From: Emily Scott [REDACTED]
Sent: 19 February 2021 17:54
To: Anita Gardner <Anita.Gardner@arun.gov.uk>
Subject: Re: FW: R/227/20/PL - 38 Oakhurst Gardens - Revised Drawings

From: Emily Scott [REDACTED]
Sent: 10 February 2021 07:05
To: Anita Gardner <Anita.Gardner@arun.gov.uk>; Peter Cleveland
[REDACTED] James Taylor
Subject: R/227/20/PL - 38 Oakhurst Gardens - Revised Drawings

Project	Laundry & Accommodation Oakhurst Gardens		Project No. 010	
Client	Littlehampton & Rustington Housing Society		Issue P1	
Date	1:50 @ A1	1:100 @ A3	Drawn ES	Checked JT
Scale / Format			Approved SM	
CAD Reference			Drawing Name Accommodation Elevations - E W Drawing No. 010-P-40-02

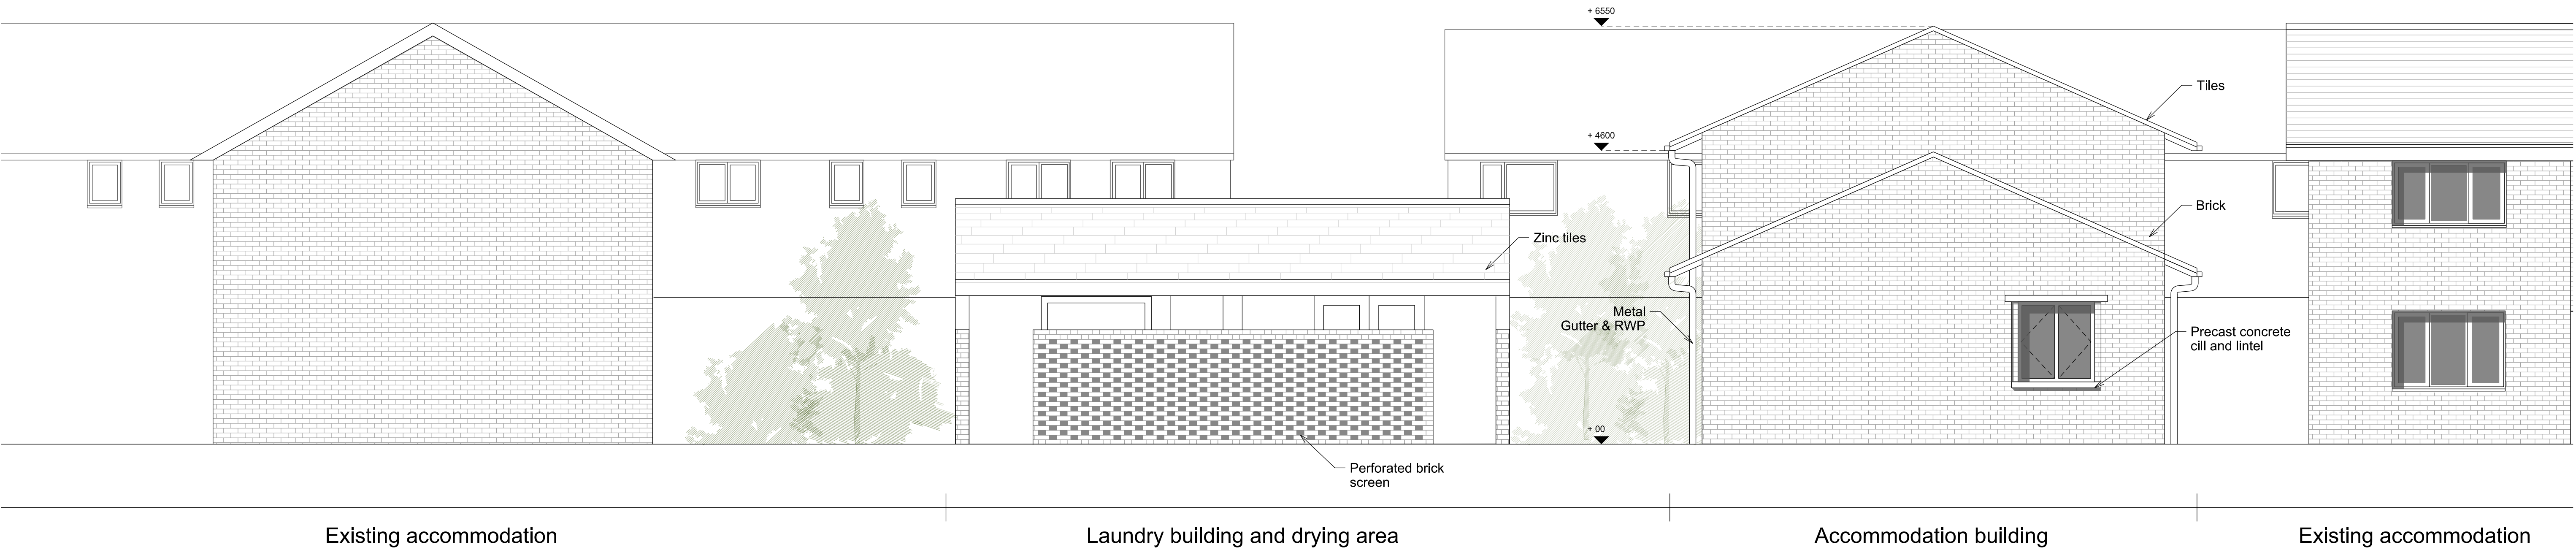
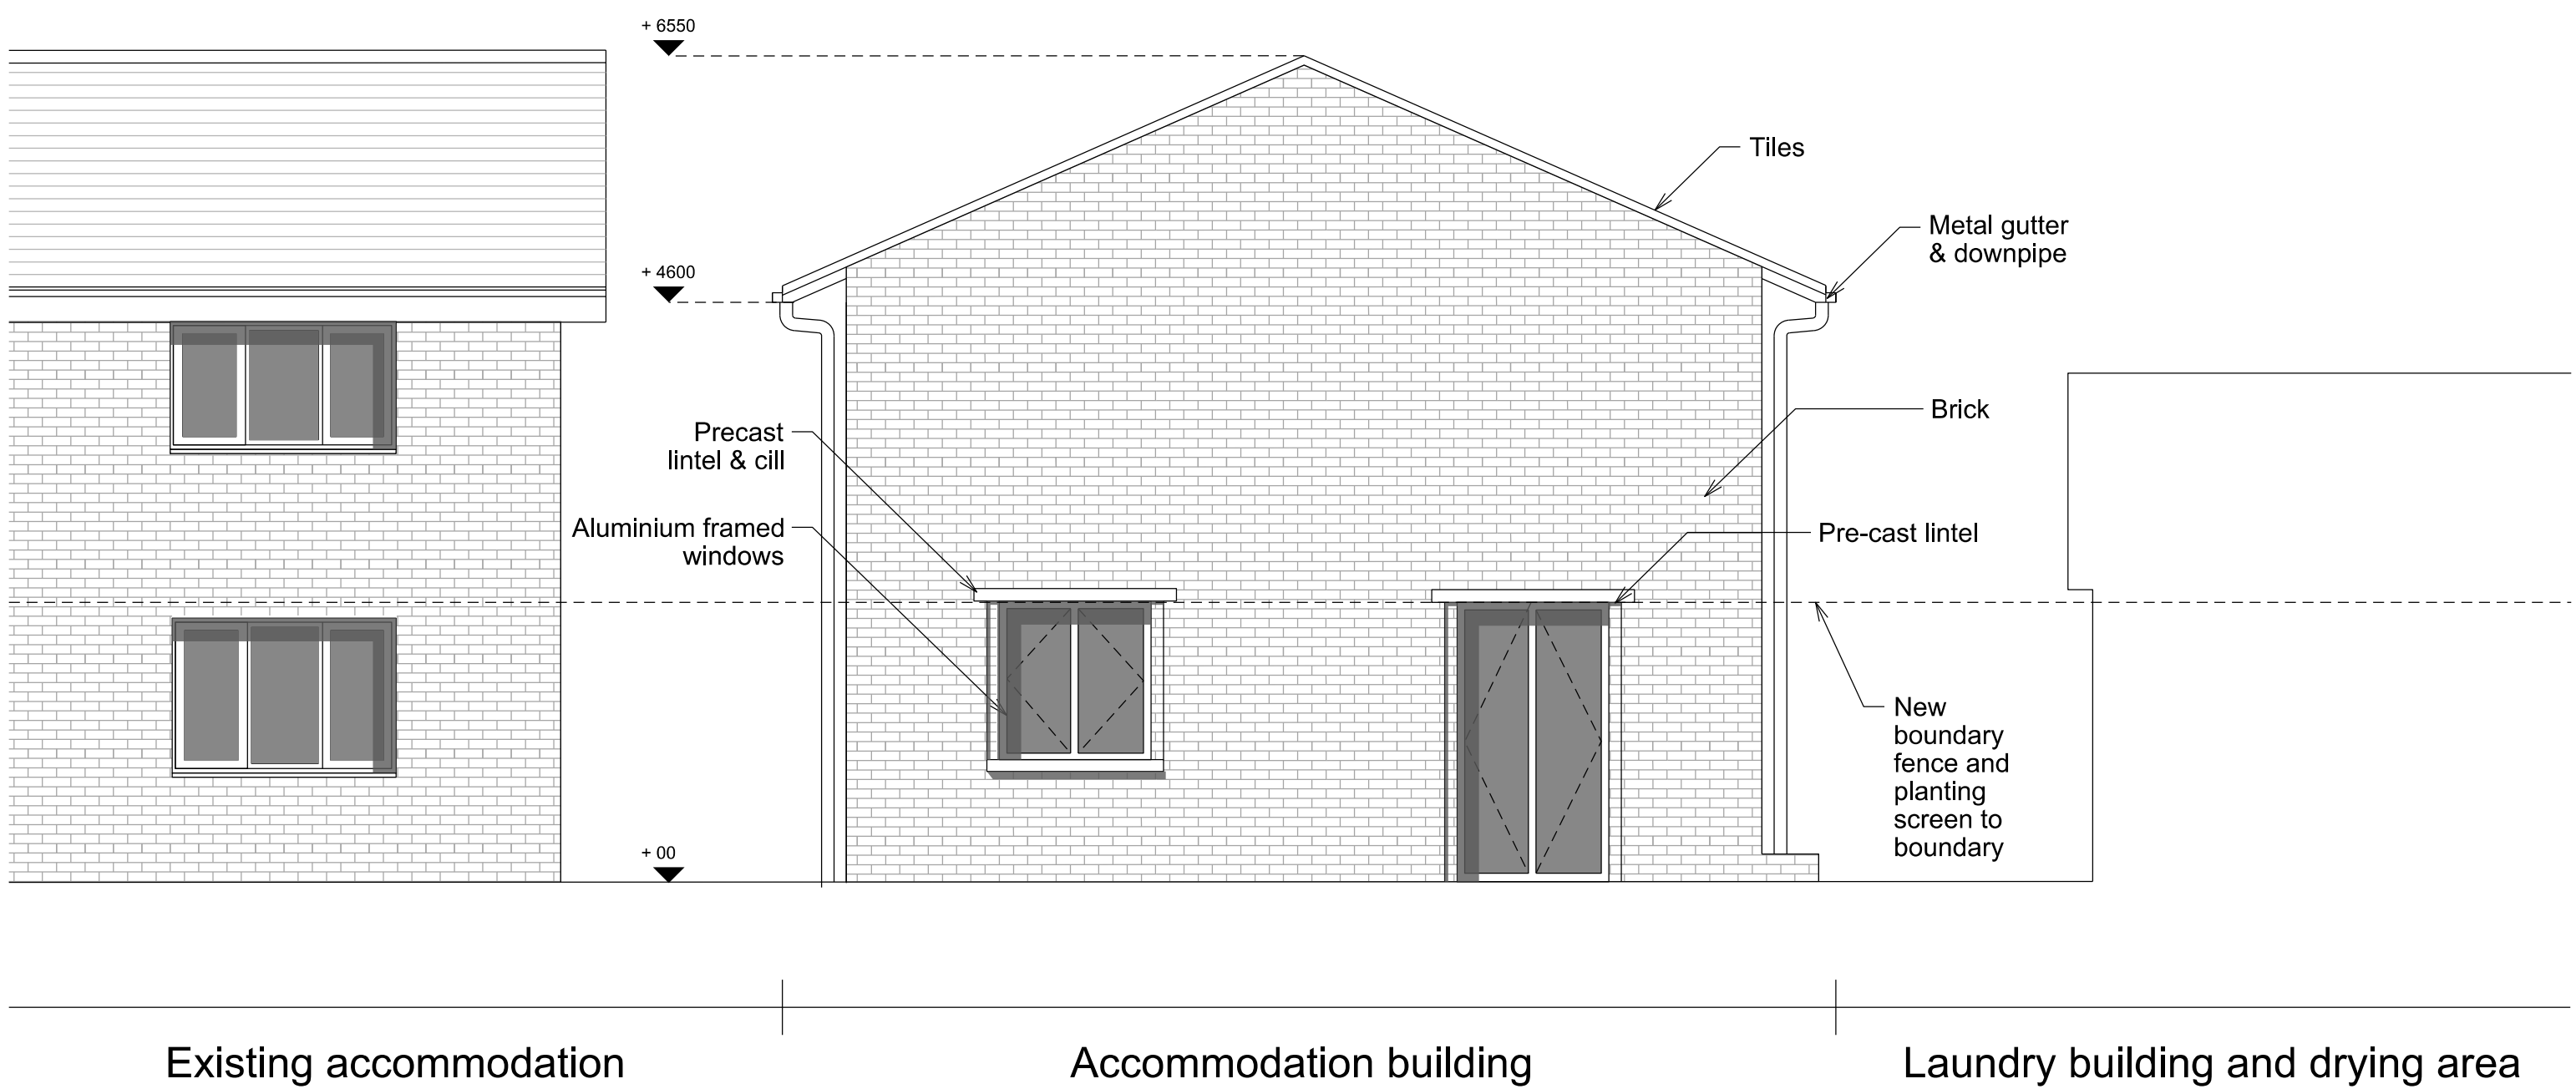
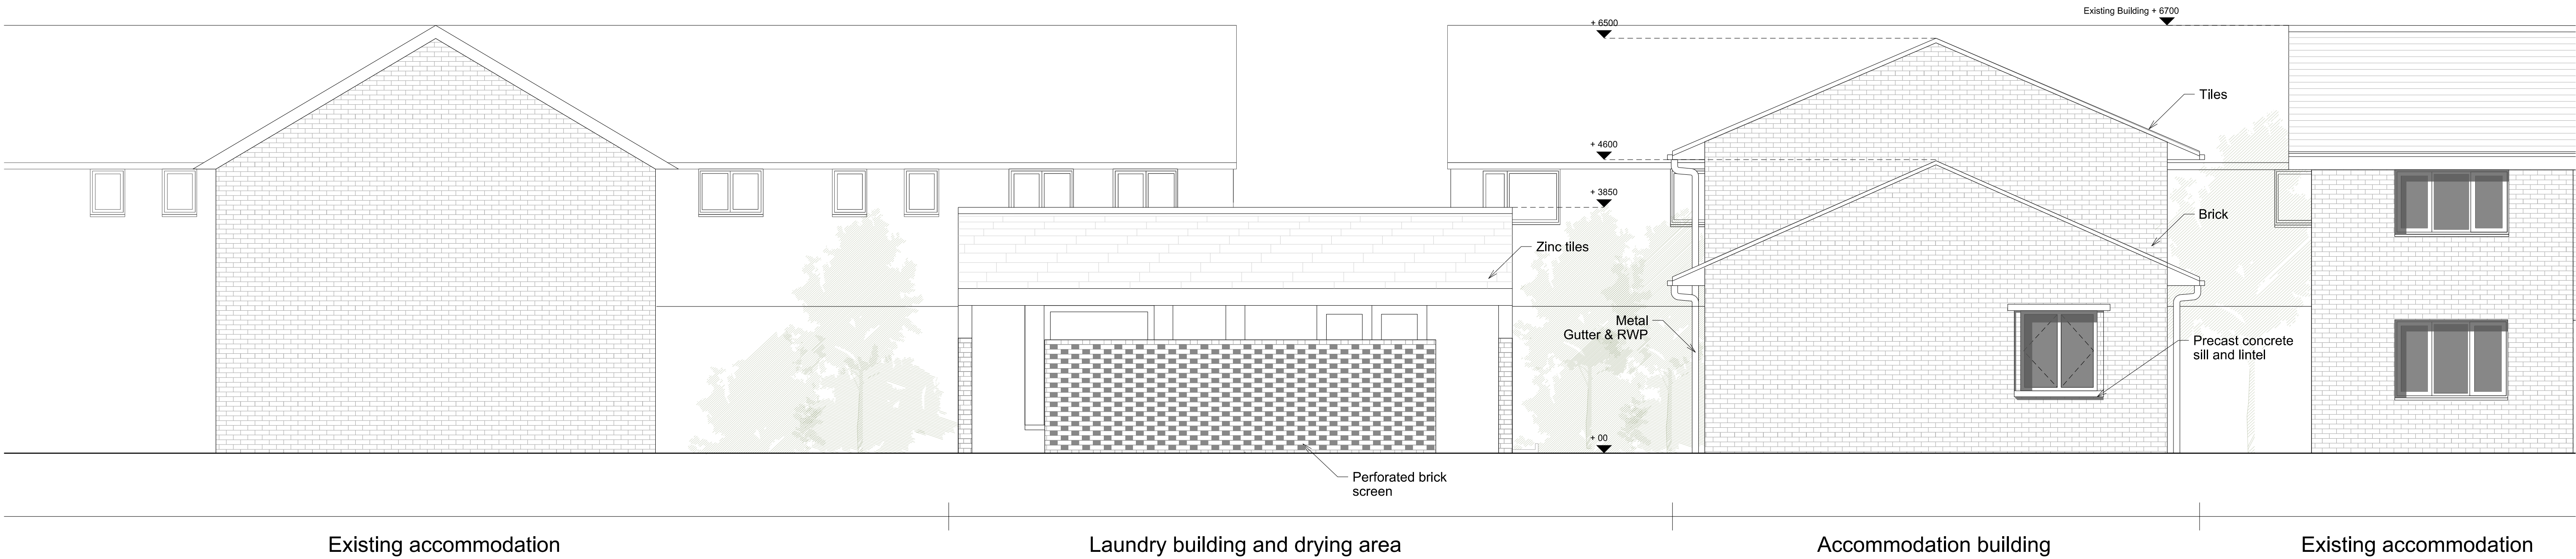
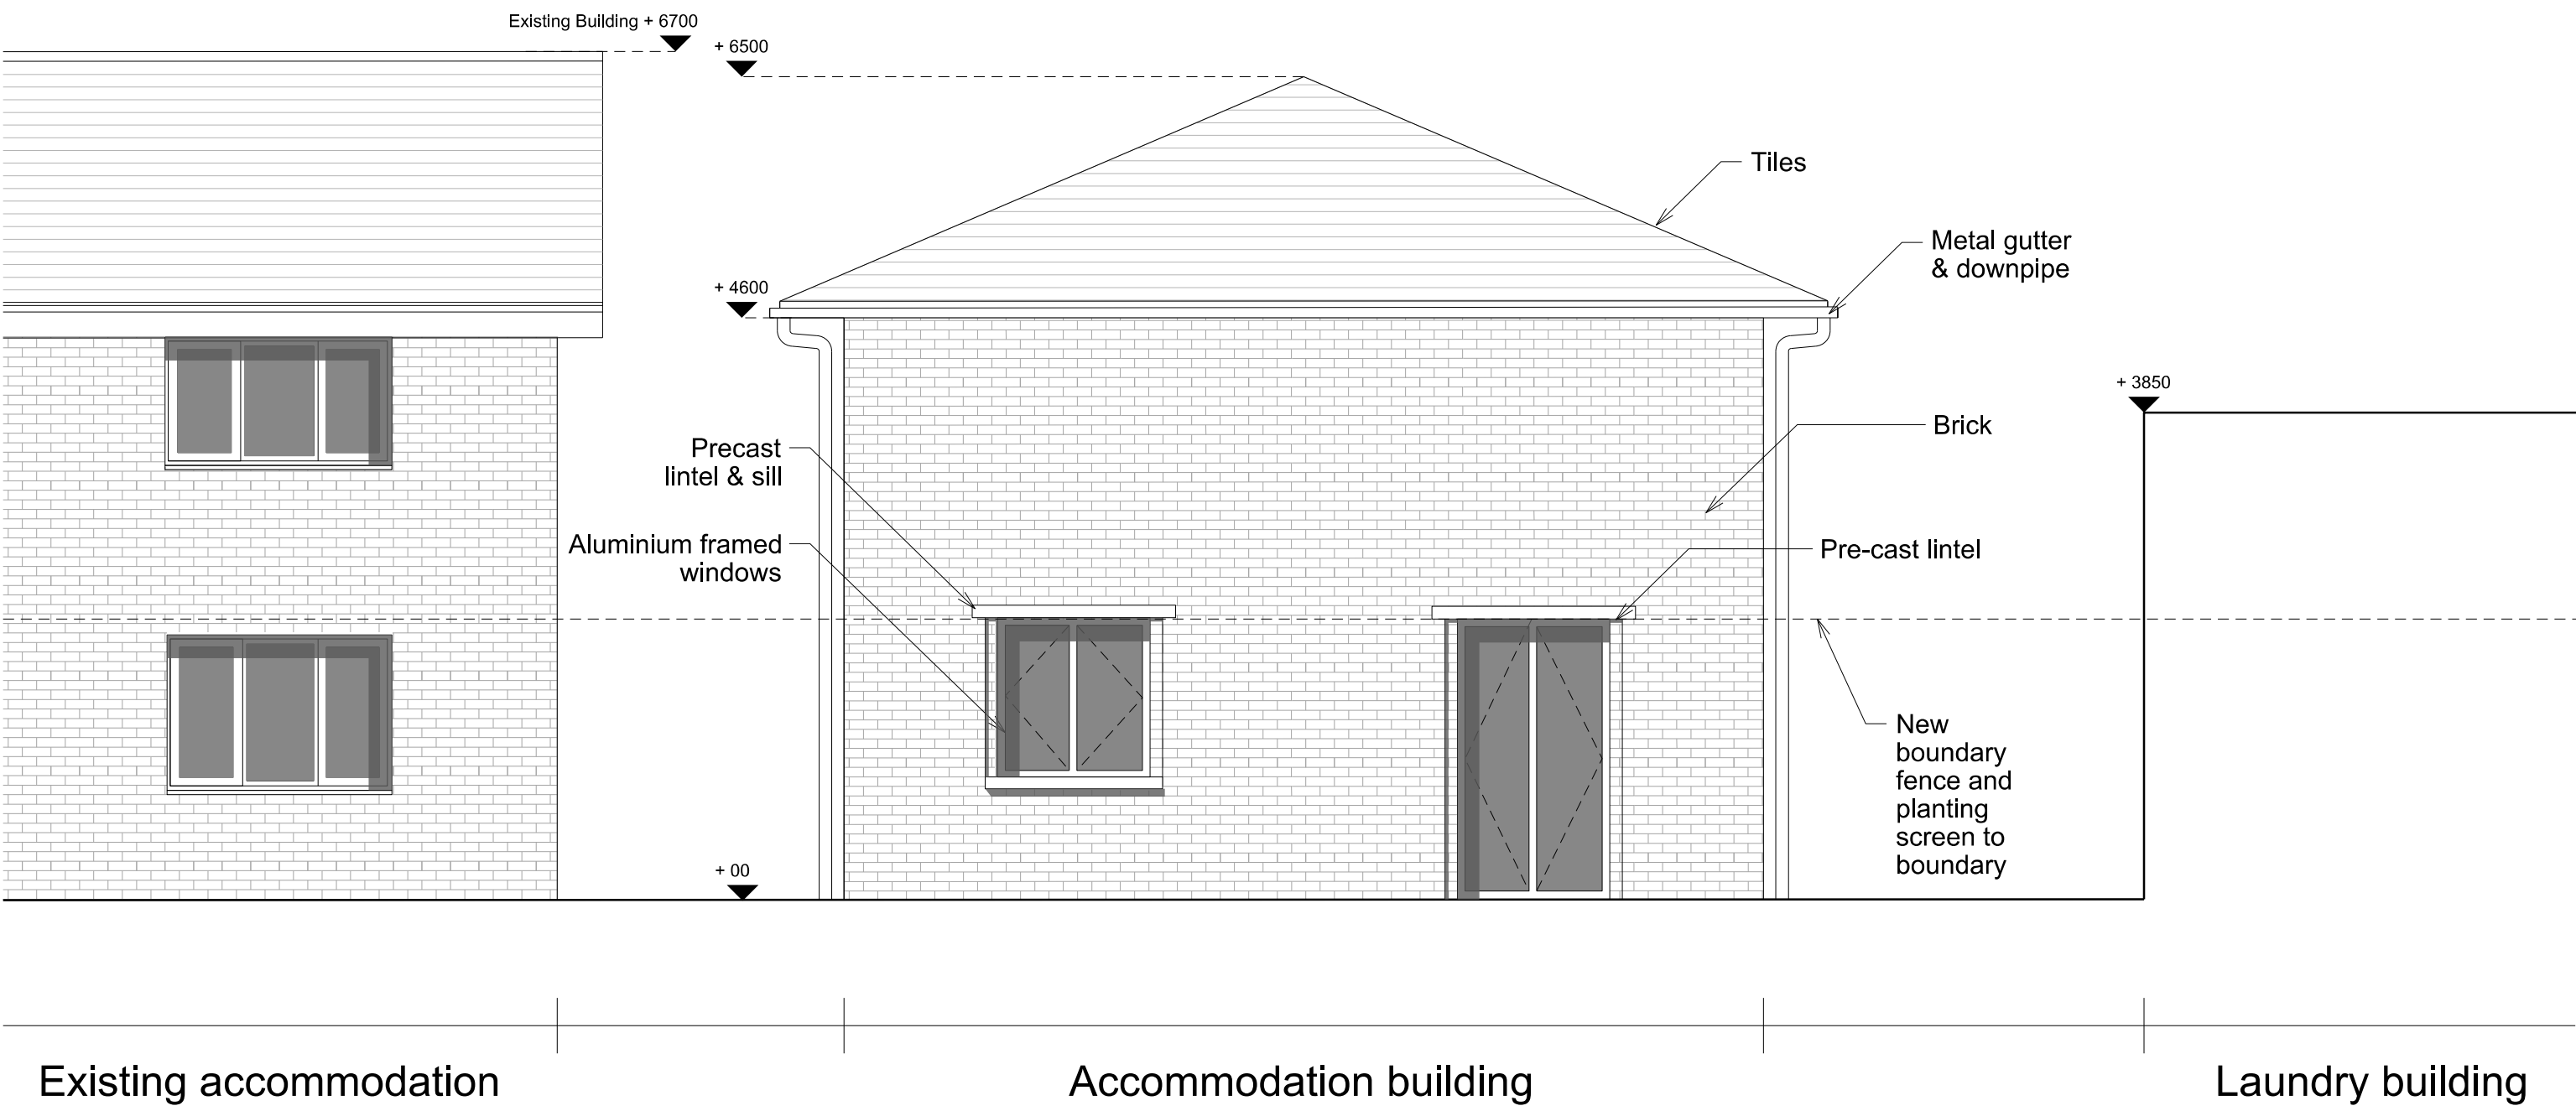
I acknowledge receipt. The plans have been forwarded to be substituted as per the issue sheet. Can you clarify how much the ridge height of the accommodation building has been reduced by?

Is it 200mm or 250mm as previously discussed? I note that you refer to it being 200mm lower than neighbouring buildings in this e-mail and previously you advised you could reduce it by 250mm.

Following previous correspondence please find attached updated drawings which show the revised roof form on the western boundary.

Please note - following further site surveys the building heights have been slightly amended. The ridge of the proposed accommodation building has been adjusted and is now approximately 200 mm lower than that of the neighbouring buildings on the site.

Thank you for the clarification. I will include a reference to 200mm reduction in my report.

The initial sketch I sent through was to determine whether these adjustments would be acceptable. Having looked at this in more detail lowering the ridge by 200mm instead of 250mm builds in some tolerance to ensure that we are able to meet guidance on floor to ceiling heights.
